12 Loraine st. Garage project

Christina Stacey <cstacey@portlandmaine.gov>
To: mattkeller13@gmail.com

Thu, Jan 12, 2017 at 2:55 PM

**BOUNDARY SURVEY FOR
 ROSS ENDRES & COURTNEY FREEMAN
 LORAIN STREET
 PORTLAND, MAINE**
OWNERS OF RECORD:
 ROSS ENDRES & COURTNEY FREEMAN
 12 LORAIN STREET
 PORTLAND, ME 04103

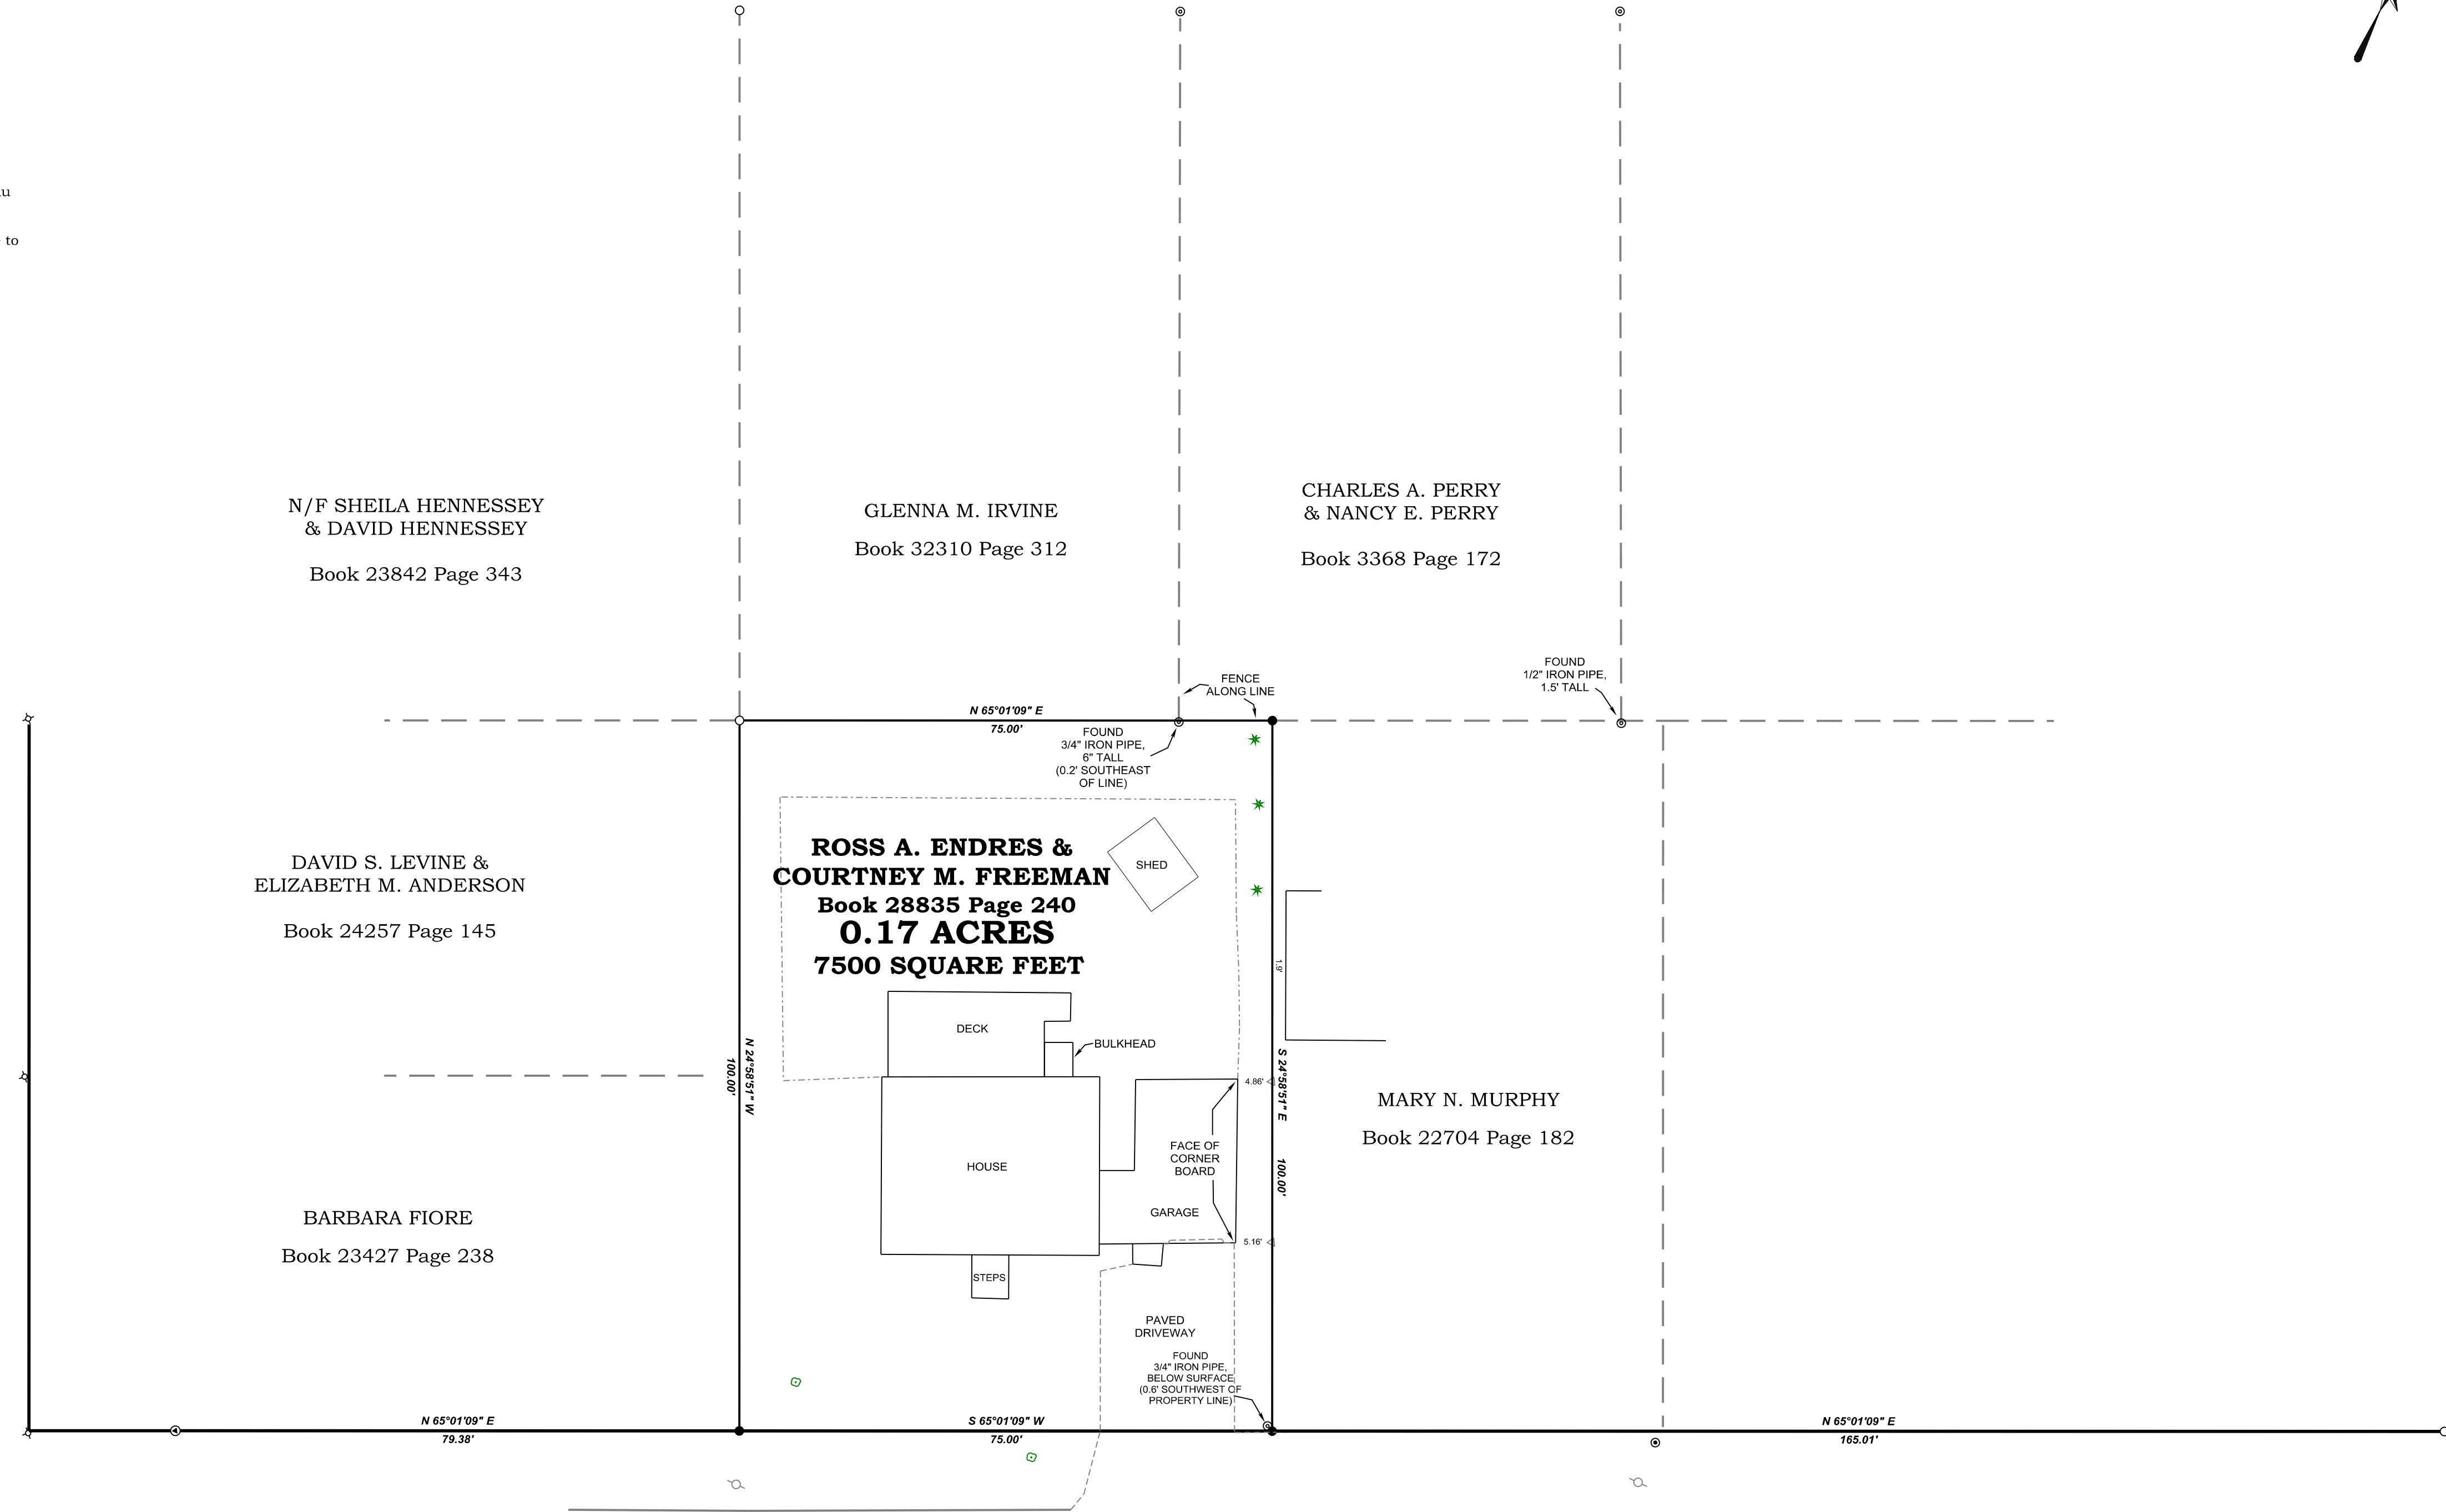
- 1) That the garage is proven to be at least 5 feet from the side property line (this may require that you enlist the services of a surveyor, as we discussed on the phone).
- 2) That the pitch of the roof does not exceed 3:12 (the plan you submitted is a little fuzzy so I can't tell exactly what the pitch says).
